Our Ref: PR107832
Date: 14 June 2013

Attn: Pilar Abersaturi
Department of Planning and Infrastructure
GPO Box 39
Sydney NSW 2001

RE: ADDENDUM TO SSD MOD 13_6003 SSD4949-2011 – 157-163 CLEVELAND STREET, REDFERN - OCCUPANTS

1 Key Plan - Ground Floor
A02.101 1:200

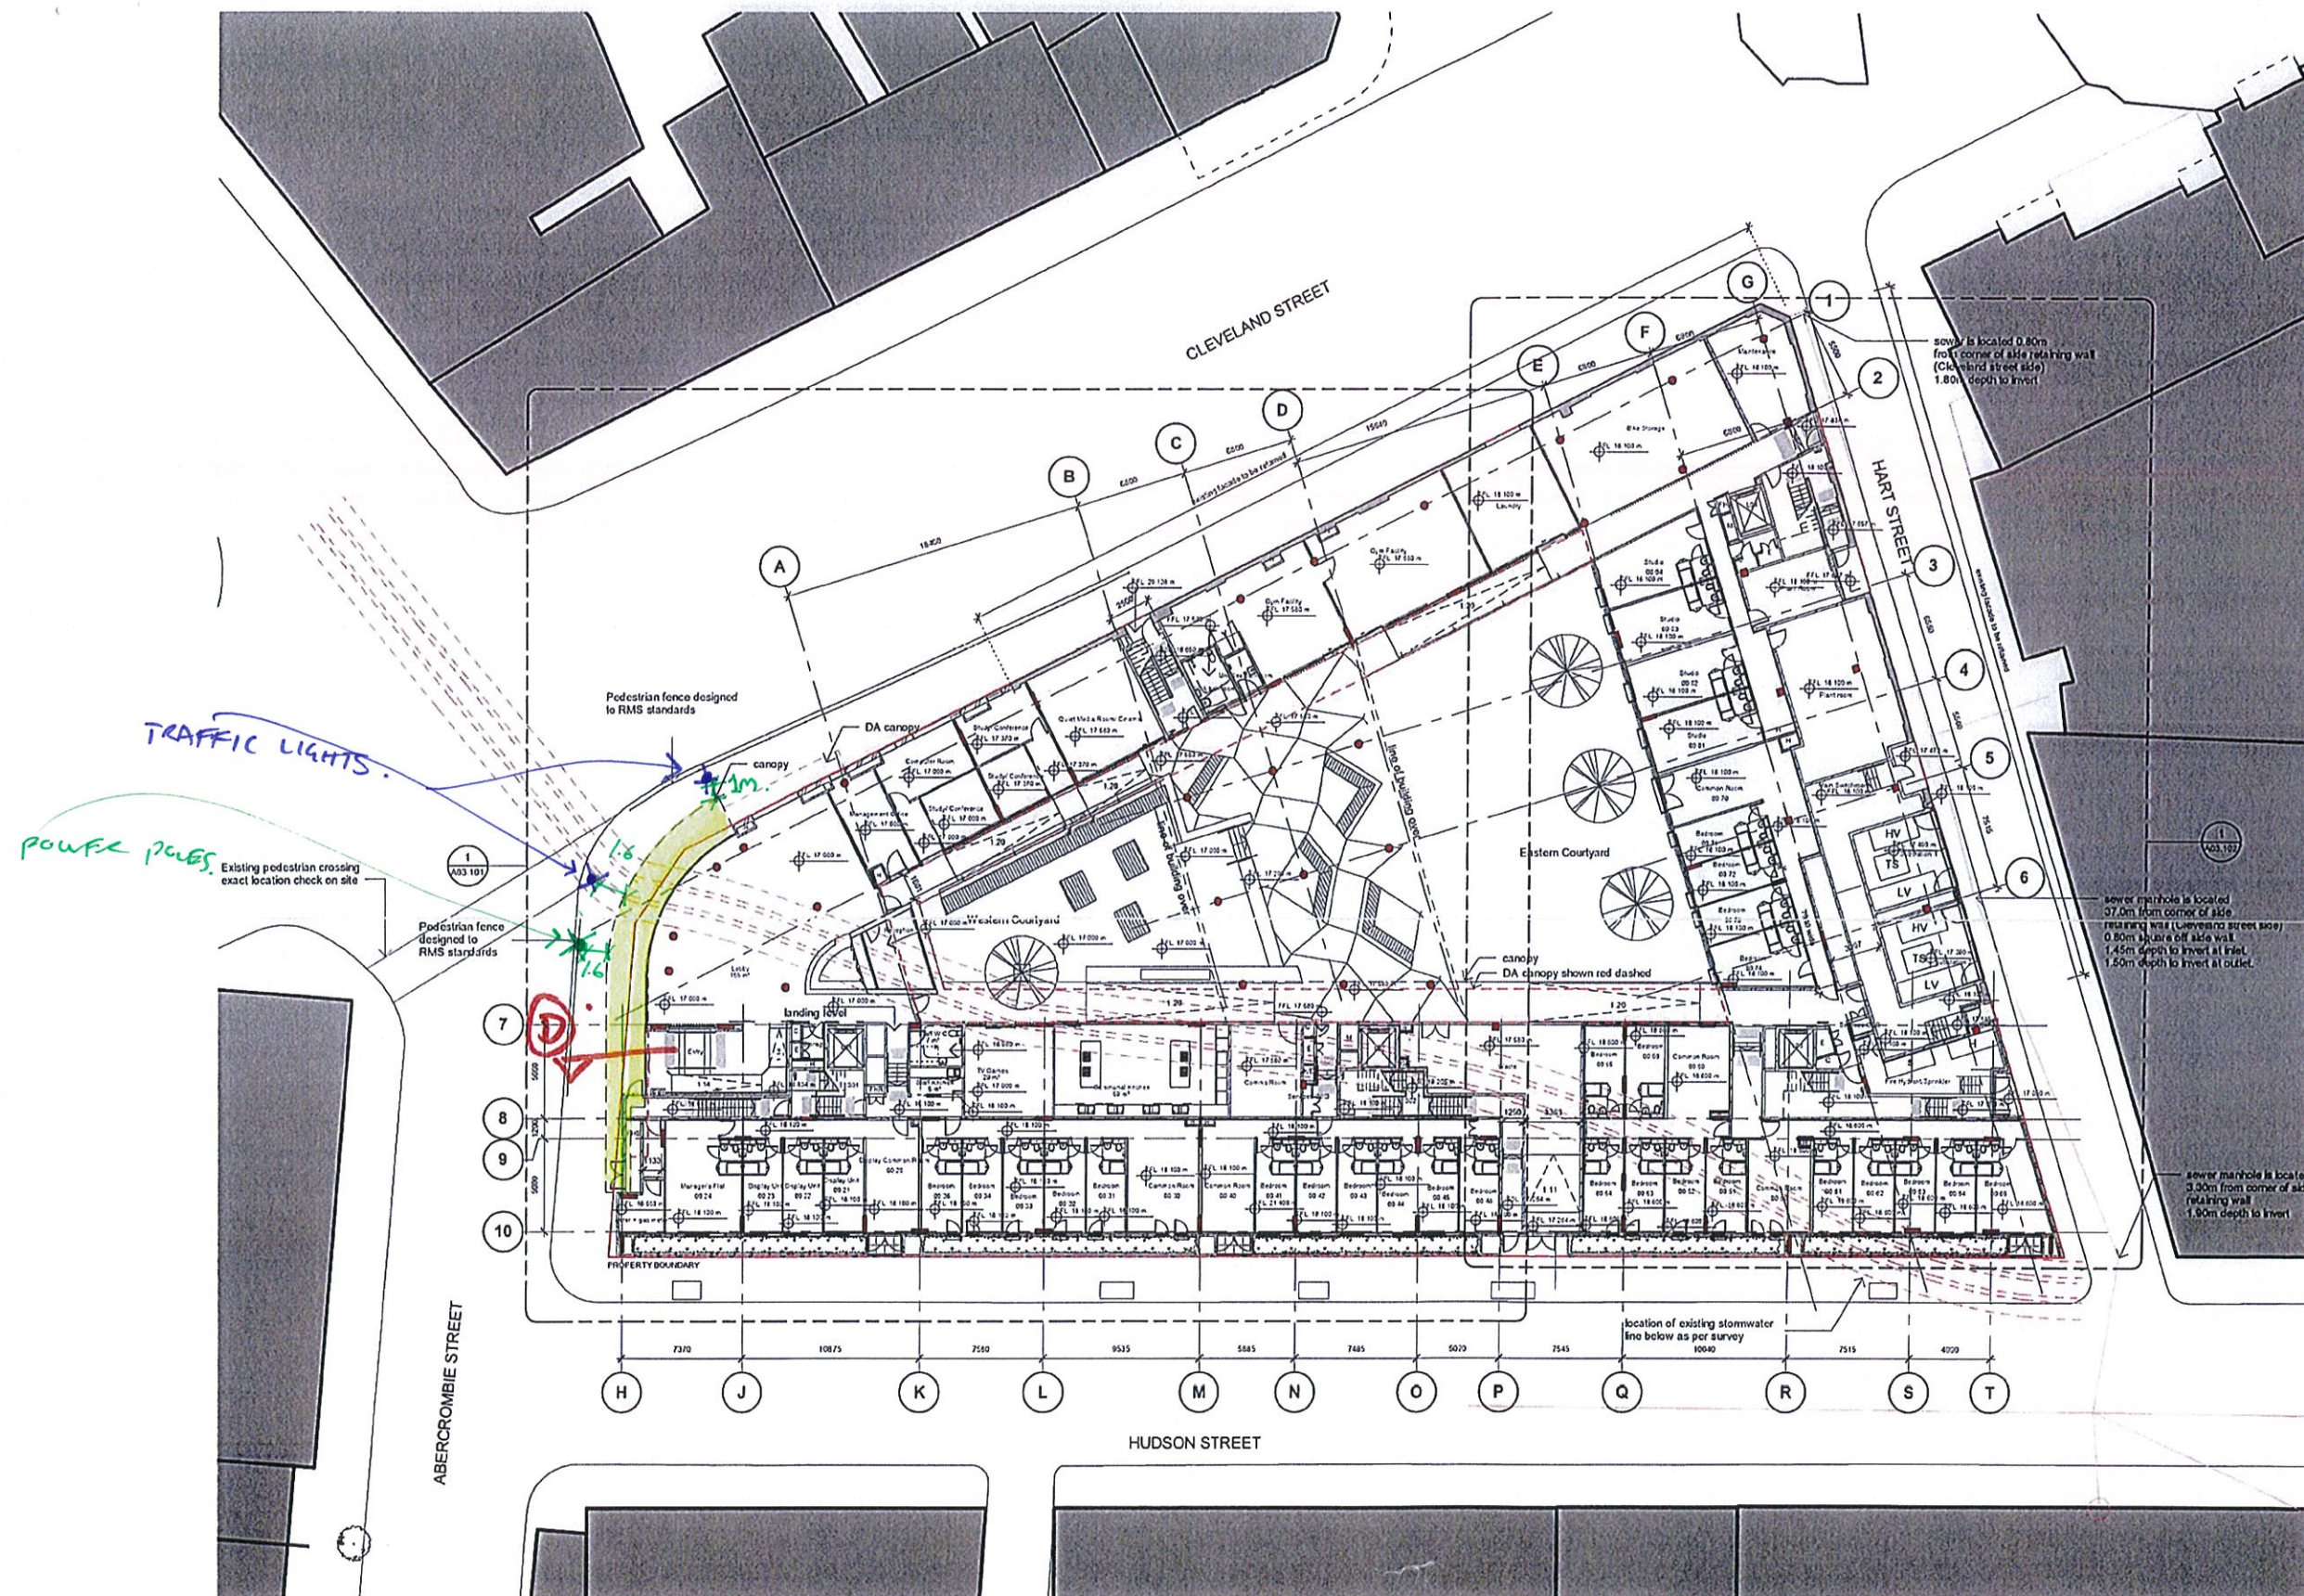
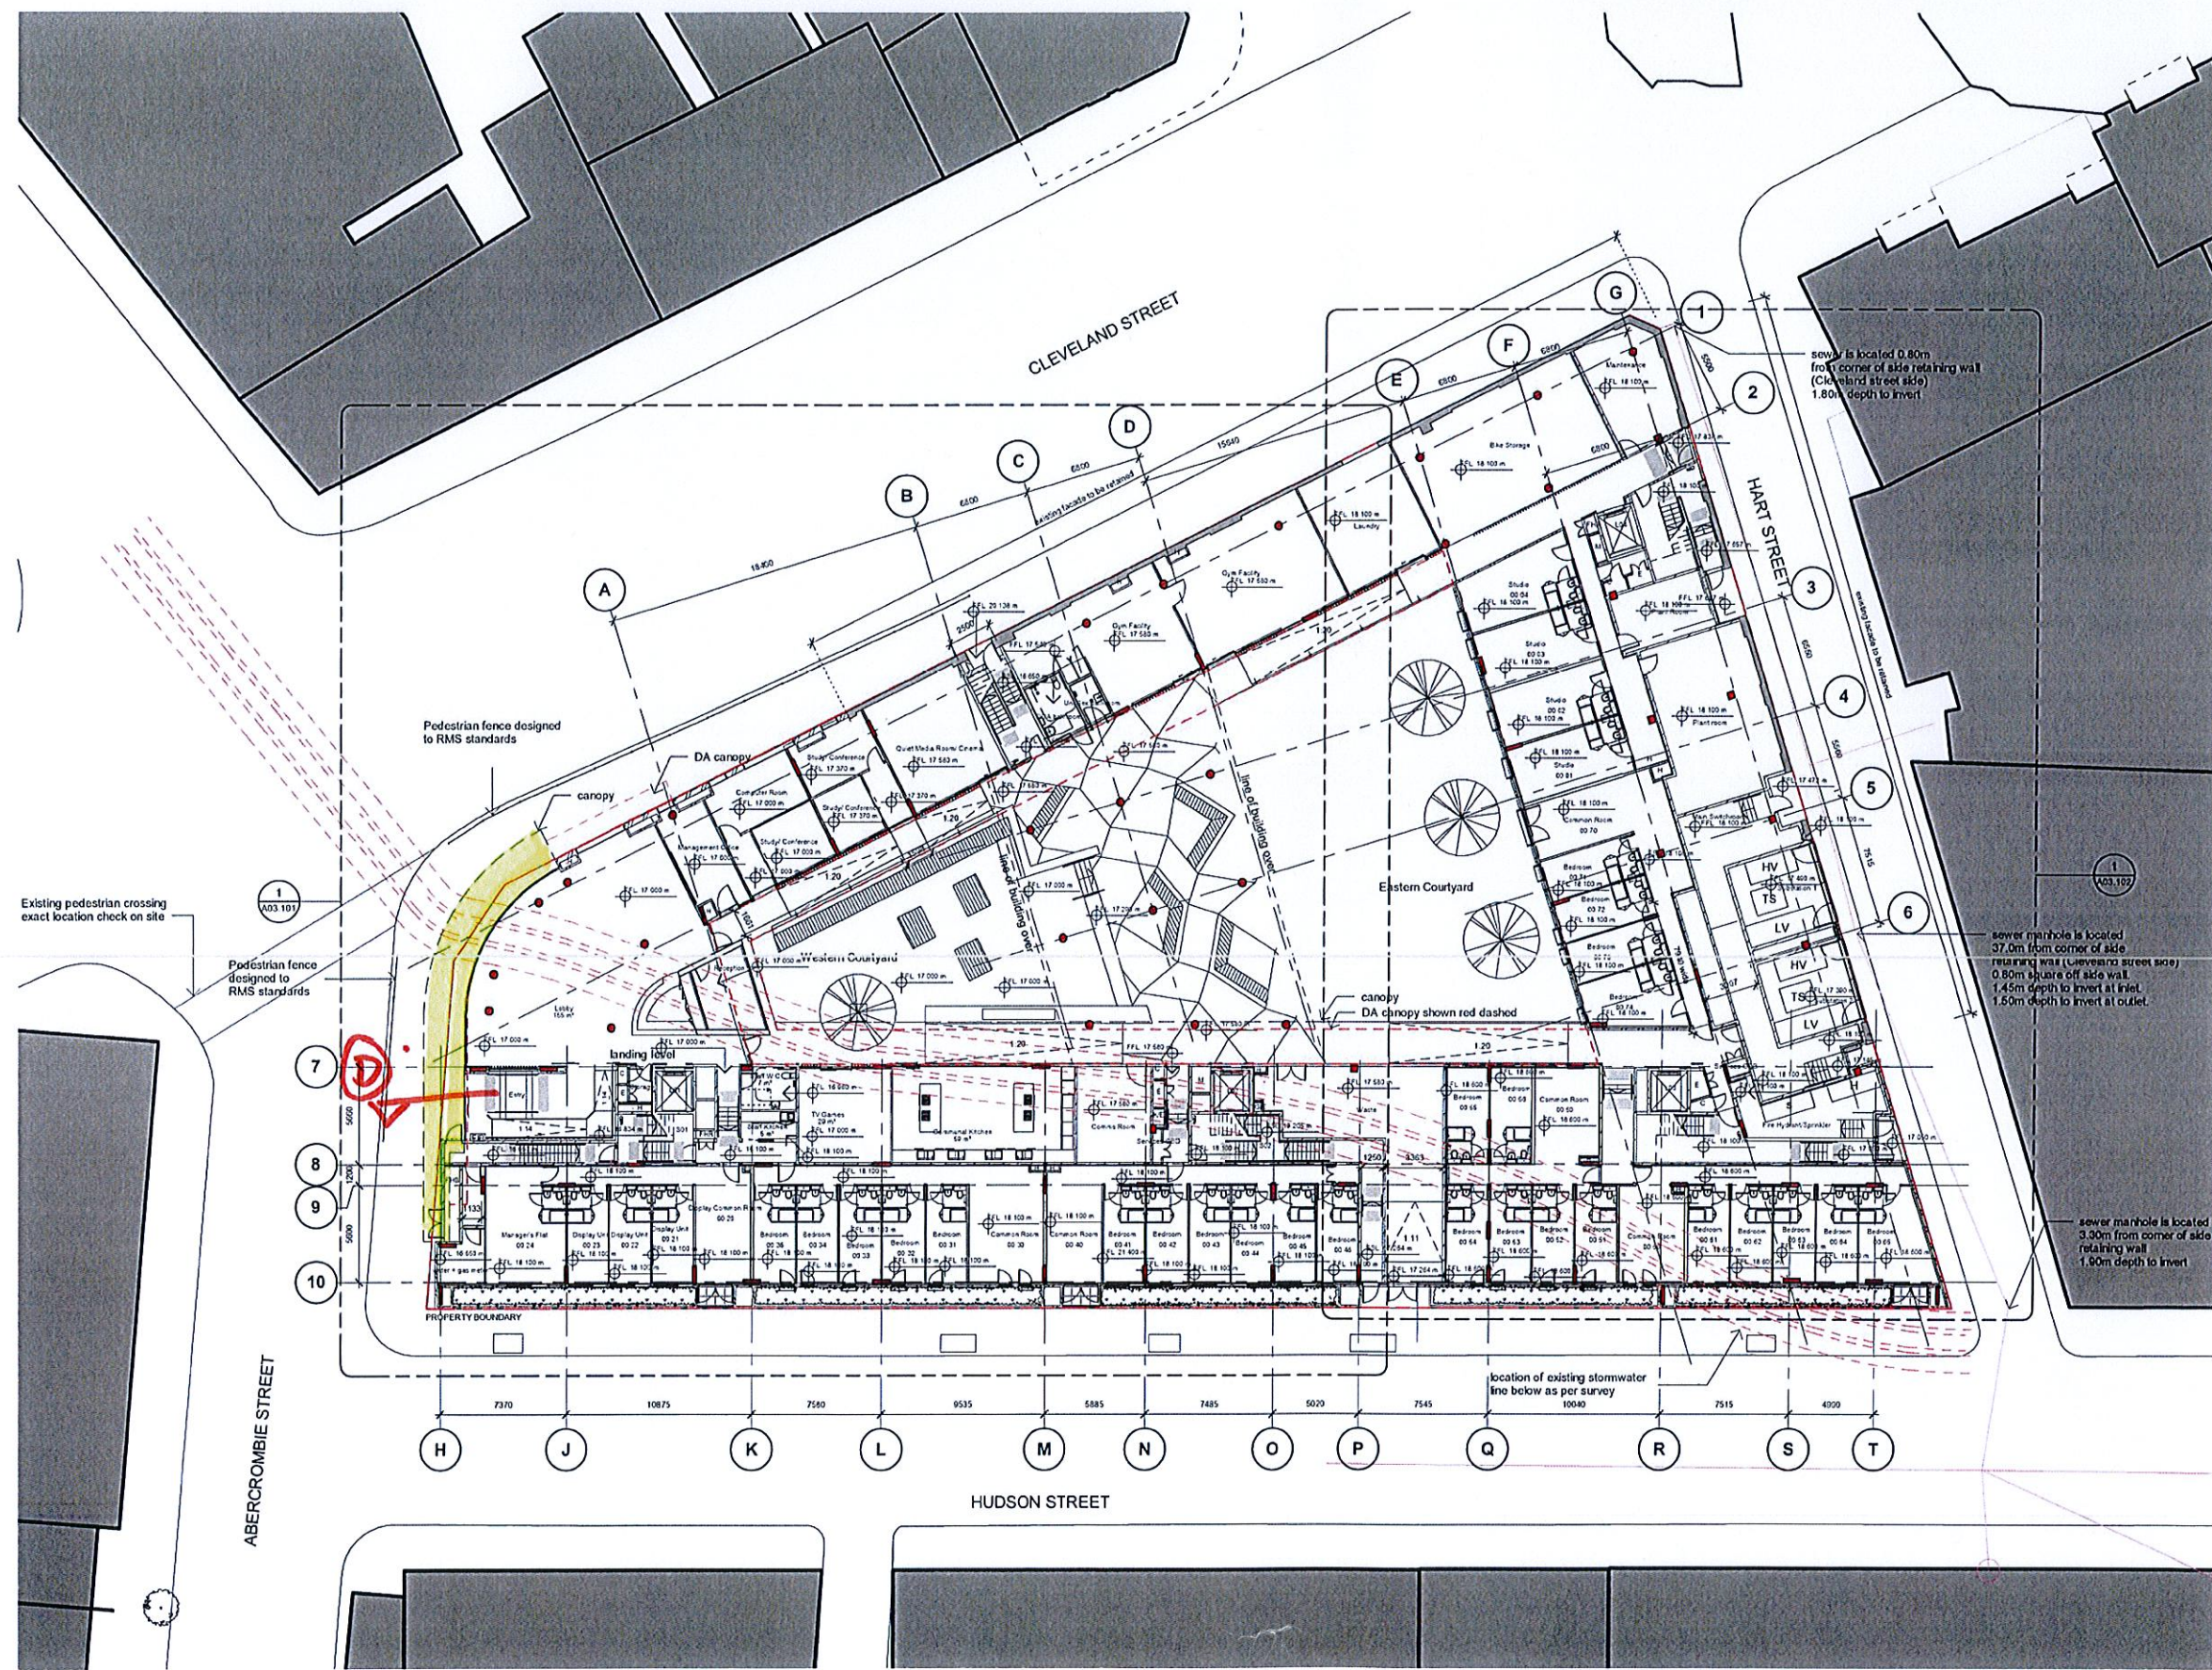
We provide this addendum in relation to the above application lodged to the Department of Planning and Infrastructure on 4 June 2013. We are seeking to amend our proposal to also incorporate the attached modification to the awning on the Cleveland and Abercrombie Street elevations.

The reason for this modification is to increase the amenity located at the front of the building and to encourage people away from Cleveland Street and onto Abercrombie Street where the front entry to the building is located.

A wider awning will also create a larger cover to directional rain rather than a narrow longer awning.
